# CITY OF ALBUQUERQUE

**Re: Los Duranes Community Center Grading and Drainage Plan  
Engineer's Stamp date 03-21-12 (H-12/D001)**

Based upon the information provided in your submittal received 03-21-12, the above referenced plan cannot be approved for Building Permit until the following comments are addressed:

GRADING AND DRAINAGE PLAN
CG-101

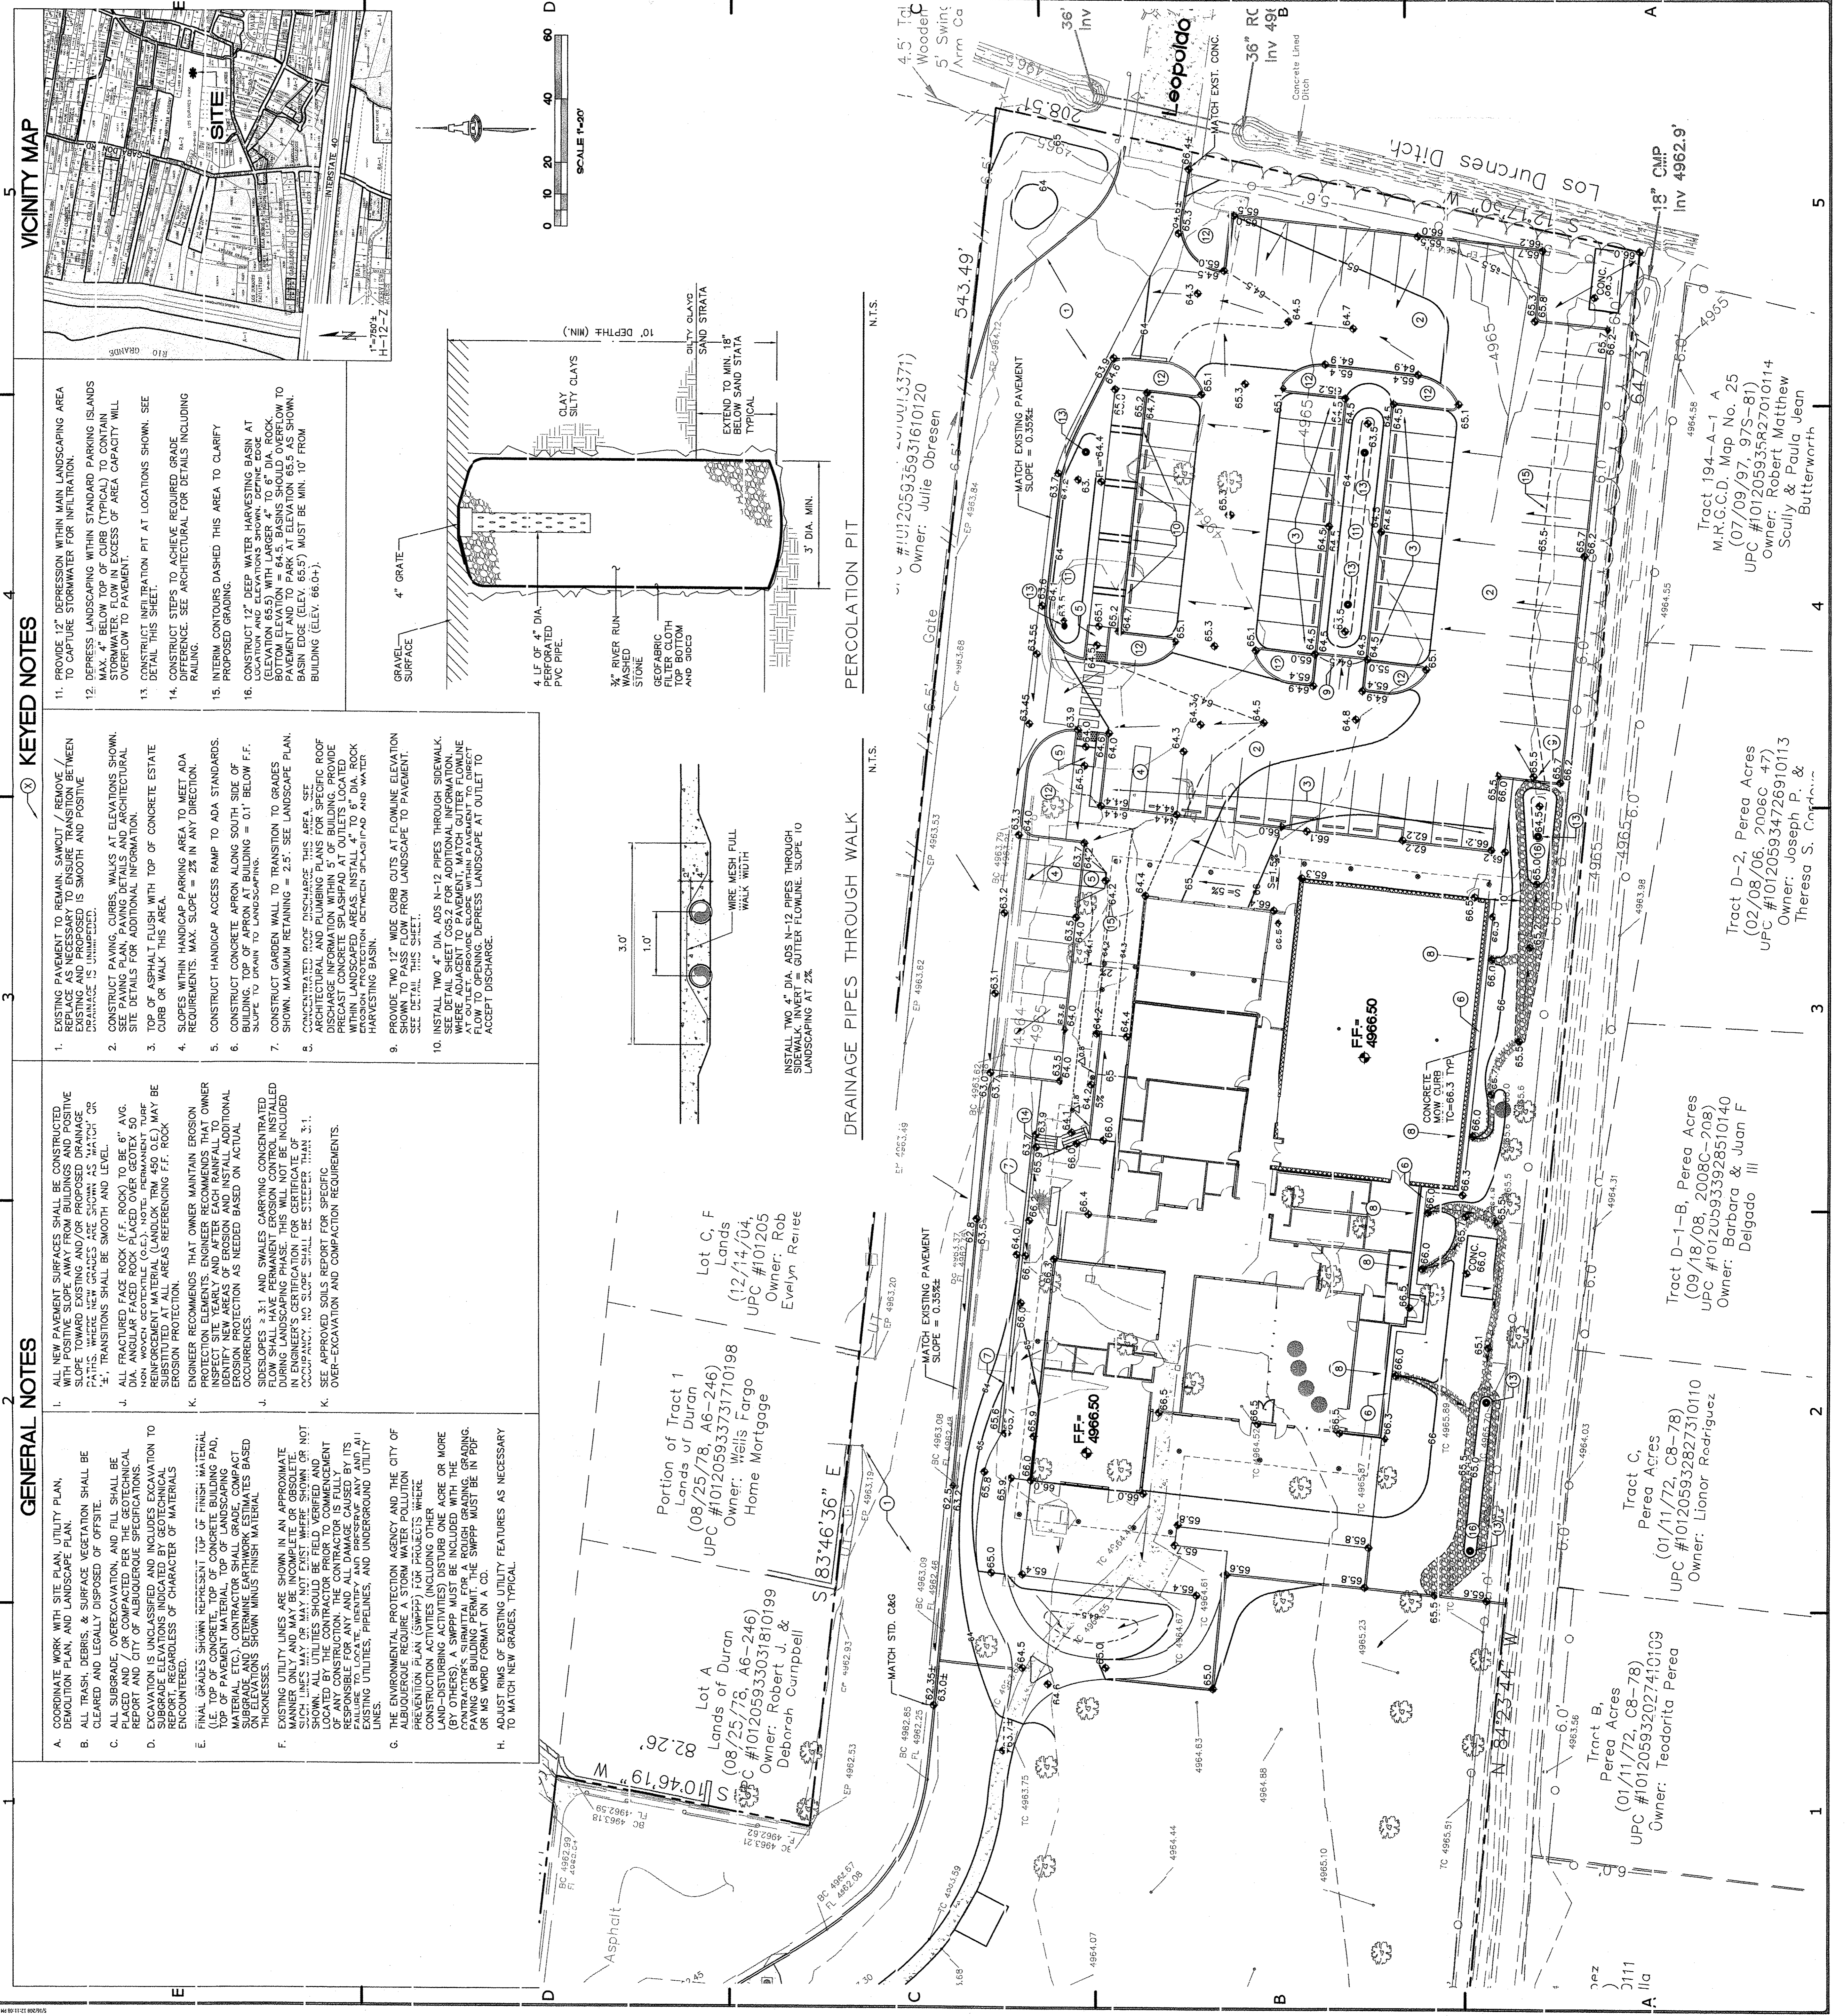
- Provide pond calculations and labels to demonstrate how the increased runoff from the new development will be limited to historic discharge (9.8 cfs).
- The "Developed Flows" portion of the drainage report should include the treatment areas for both B and C treatment types. These values should not be zero.
